northern
beaches
council

28 July 2020

**St Luke's Grammar School Senior Campus and Sports Centre
210 Headland Road, and 800 Pittwater Road, Dee Why 224 Headland Road North Curl
Curl (SSD-10463)**

2 SIGNAGE TYPE 2

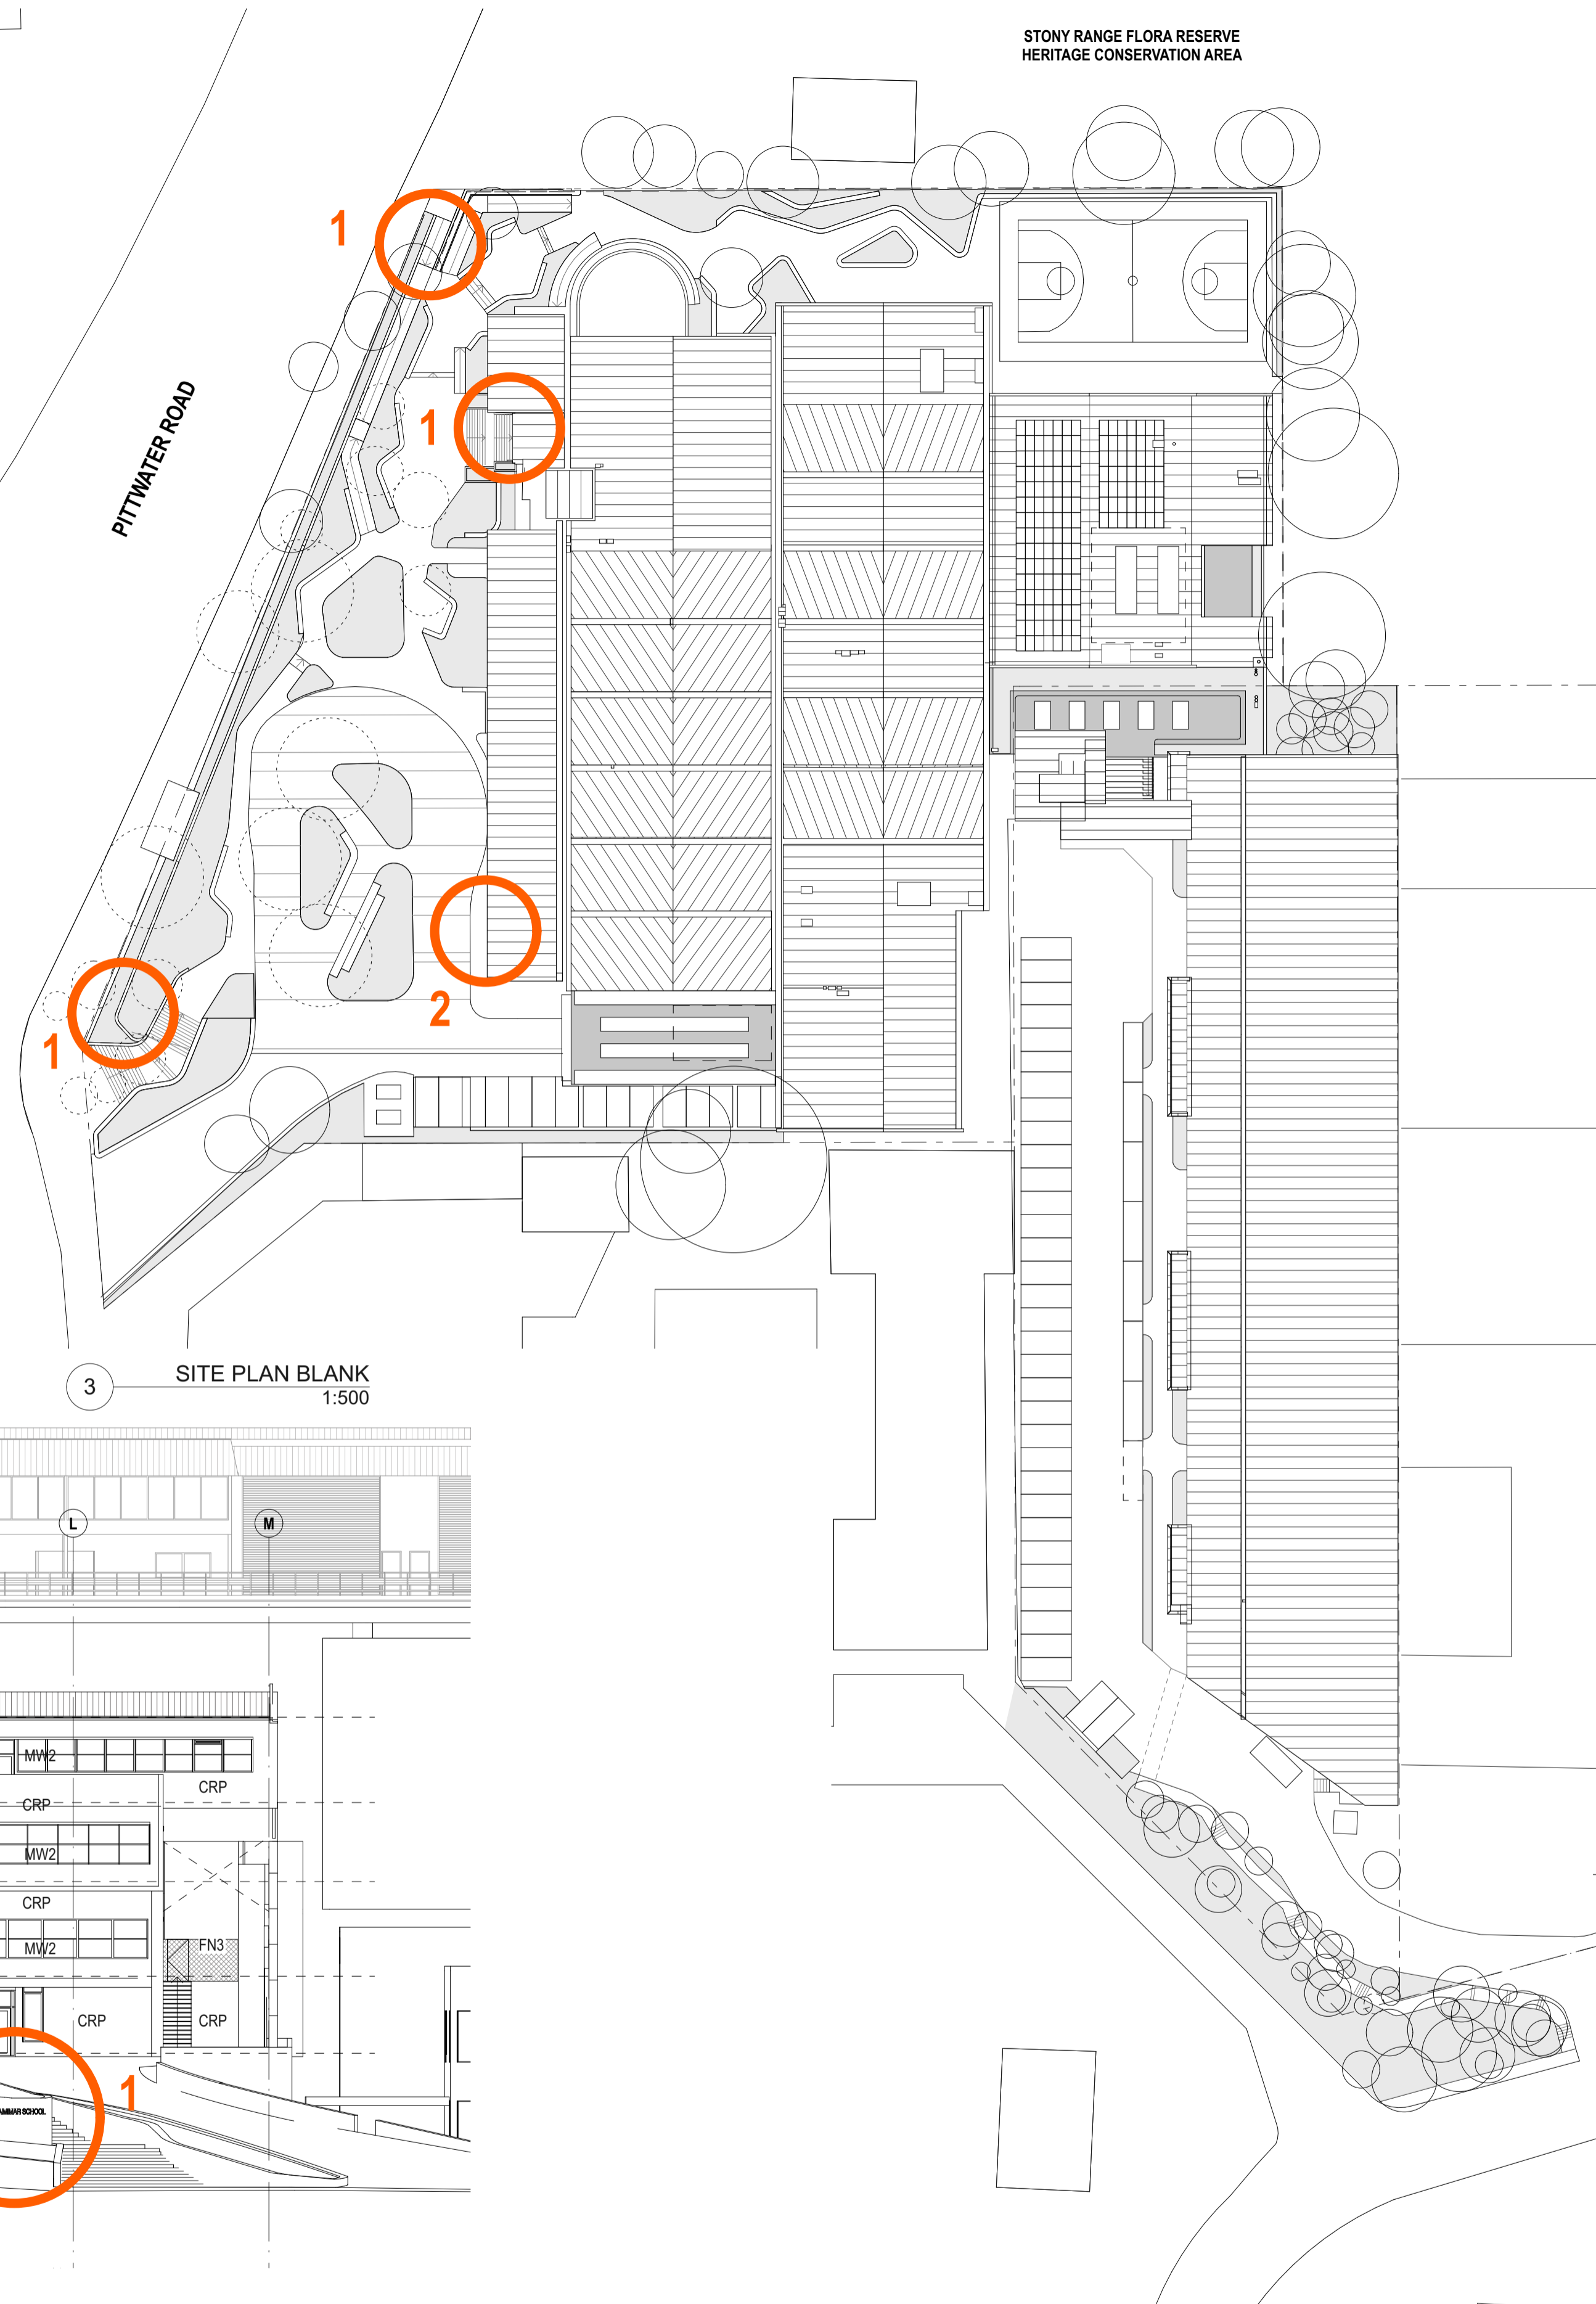
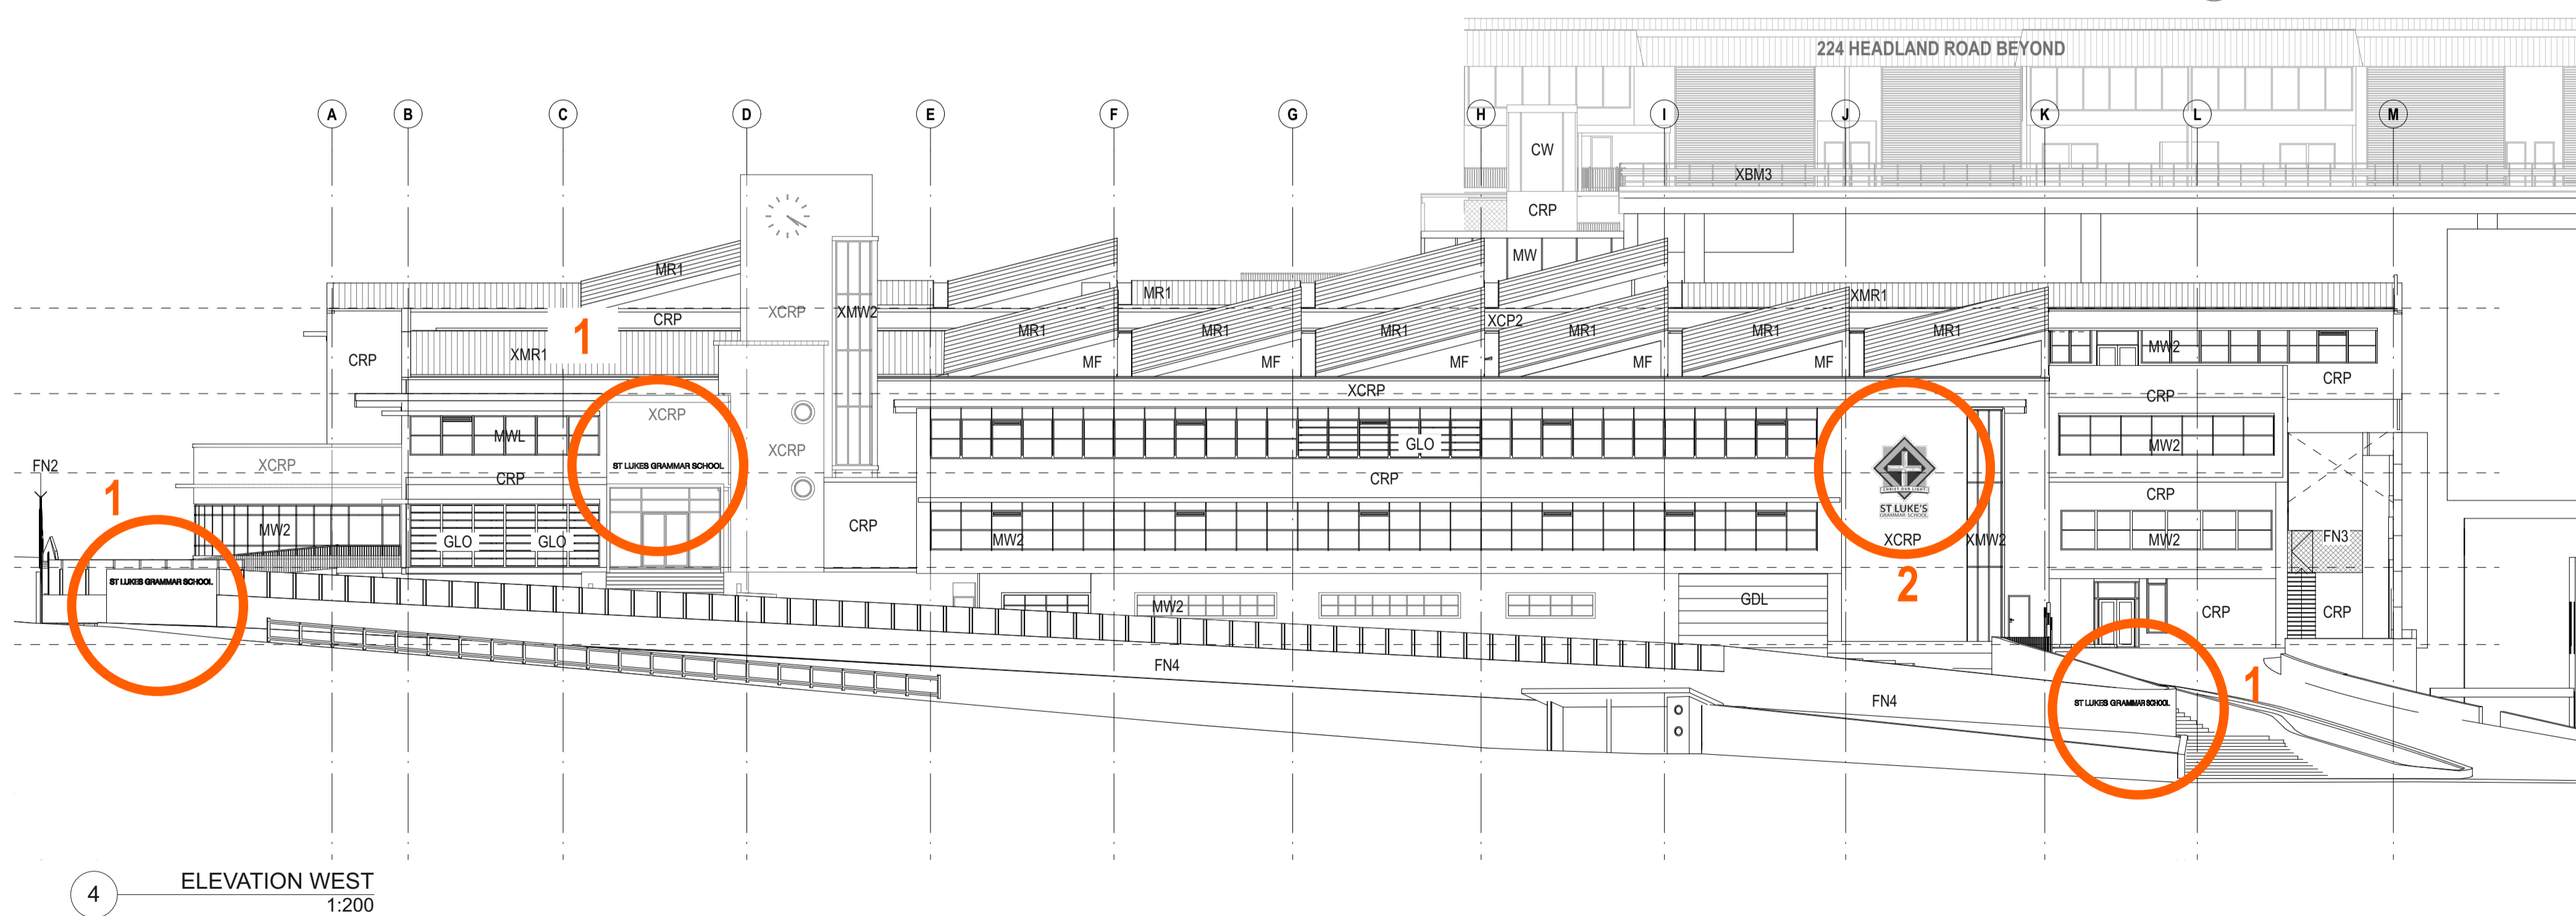
Proposed signage is generally acceptable. However, consideration should be given to a reduction in the size of proposed Sign 2, the main sign on the southern end of the front facade, so that it does not dominate the facade and compete with the heritage clock tower.

1 ELEVATION WEST
1:200

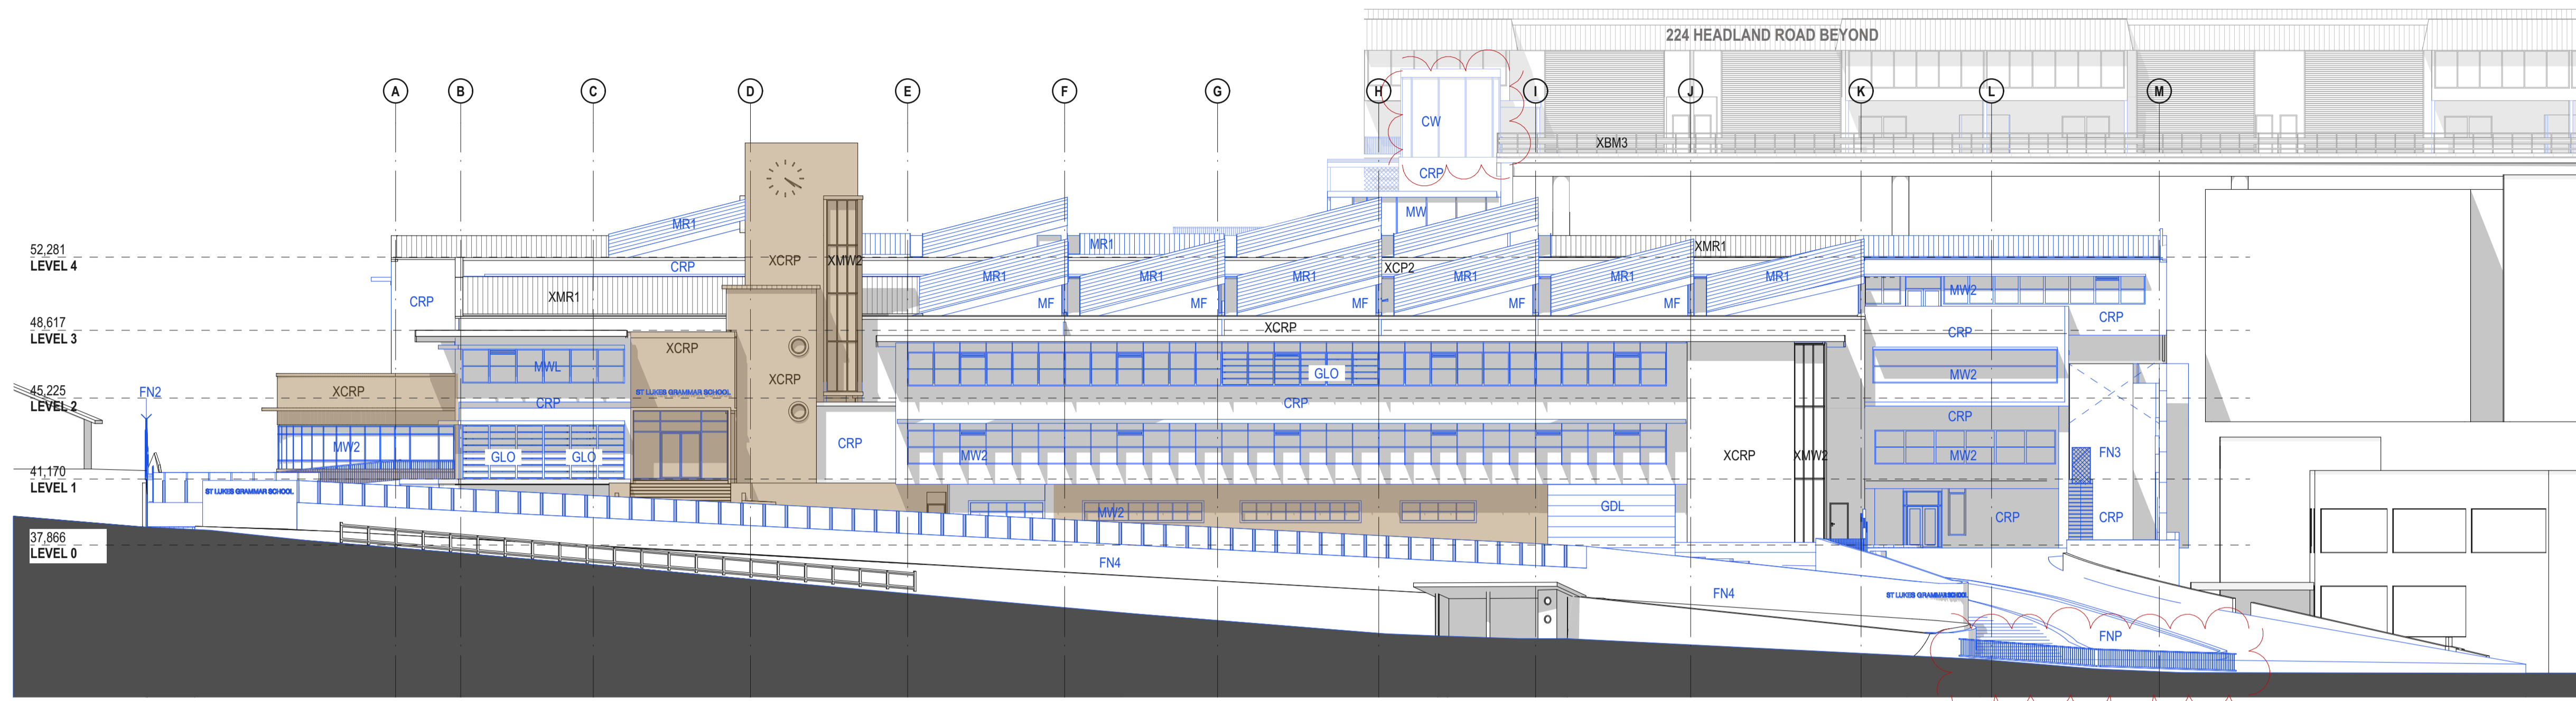
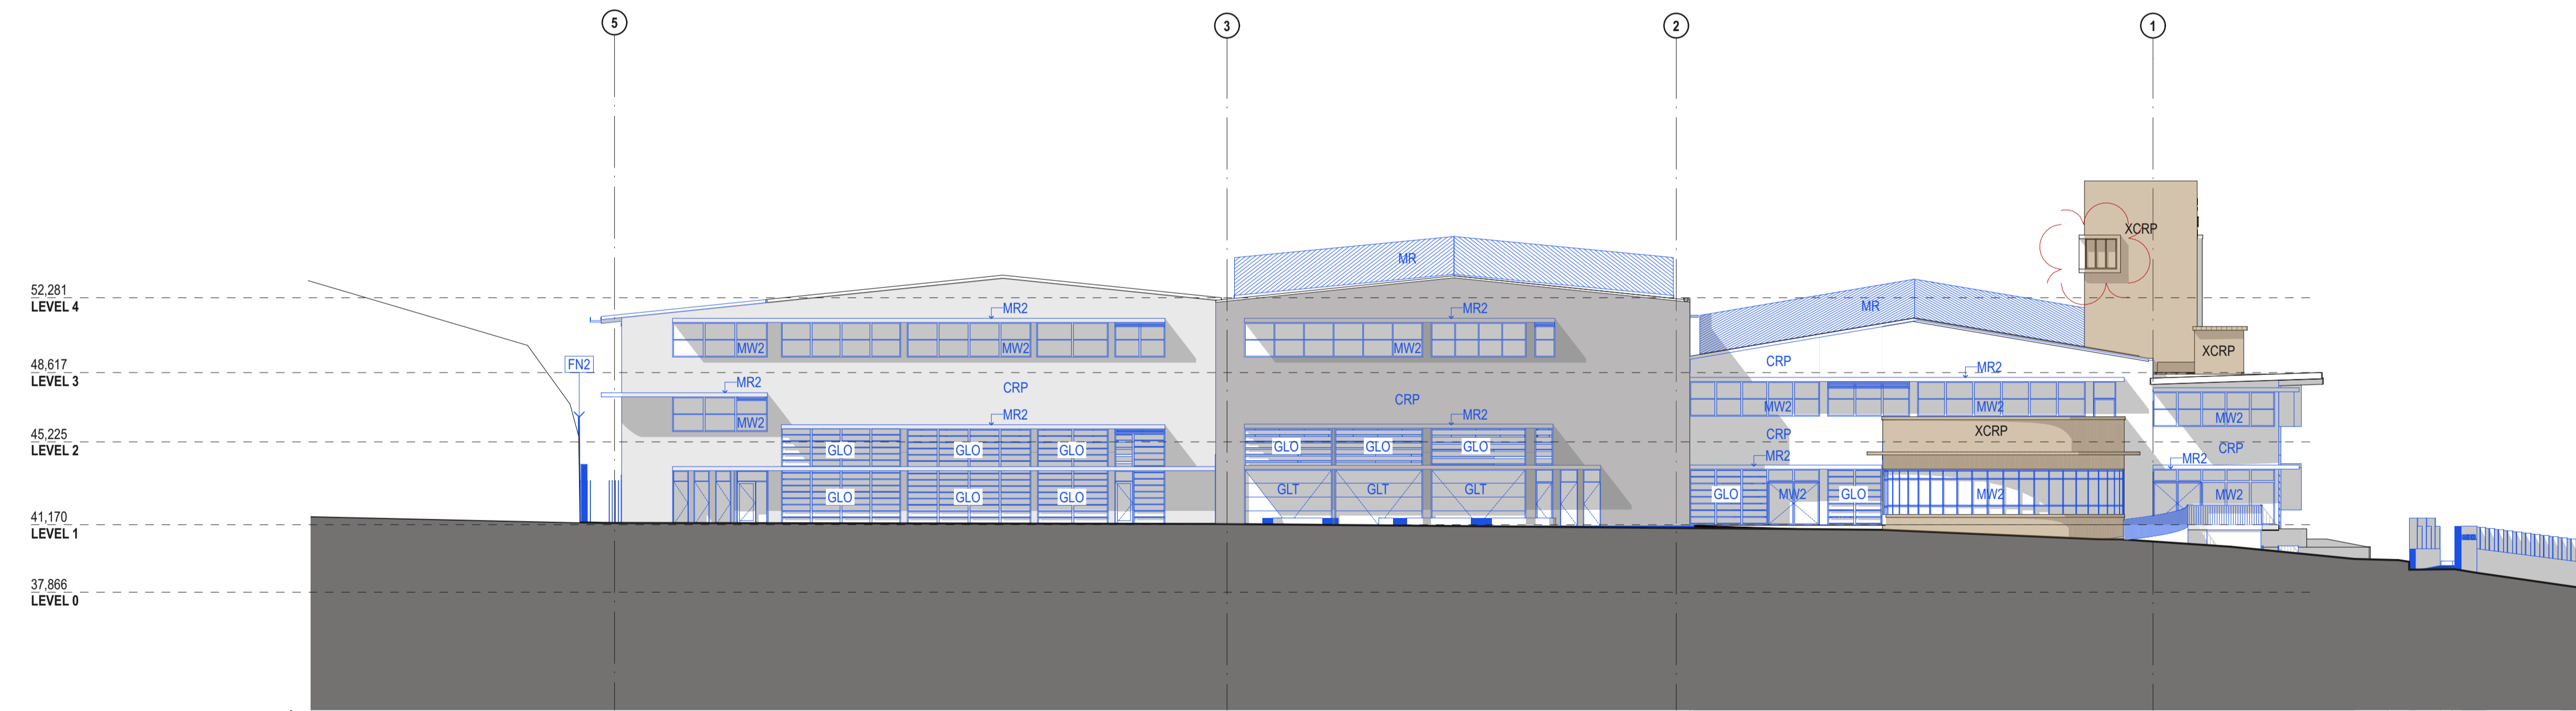
The new design fails to interpret the solidity and fenestration pattern of the original facade. The existing glazing on the western facade is proposed to be replaced with a new facade of solidity and fenestration which is not a lot different than the existing in terms of the location of the external walls.

The original facade was located behind the leading edge of the clock tower with a parapet and recessed upper storey facade as well a large overhang. Similarly, the area to the left of the main entrance was also behind the leading edge of the tower. This original design ensured that the asymmetrical clock tower and building entrance took prominence as part of the original design, which has been lost in later additions.

While the proposal does adopt a strong horizontal architectural statement, by adopting the line of the current Officeworks building for its new walls and large overhangs, this component will continue to affect views to and from the clock tower. It would be preferable if the overhangs are removed and the upper section on the southern end recessed, thereby reinstating the original parapet wall. This will help to interpret the solidity and fenestration and the articulation of the original fabric. Slightly recessed glazing behind this parapet wall could complete the second storey. By doing this the proposed second storey area will need to be reduced (a reduction in the size of the proposed atrium may be considered to regain the required internal area).

The original colonnade on the ground floor should be reinstated. This again will result in a slightly reduced internal floor area but will help the building to regain its original fabric on the western facade.

A similar design approach should apply to both sides of the main entry on the western facade, so as to retain the prominence of the tower element and also retain significant views to the tower and to the semi-circular canteen element at the north-west end of the building.

The plans and renders provided do not show the existing window on the north-eastern corner of the heritage listed tower. This window must remain and must not be removed as it is an essential element of this heritage listed structure.
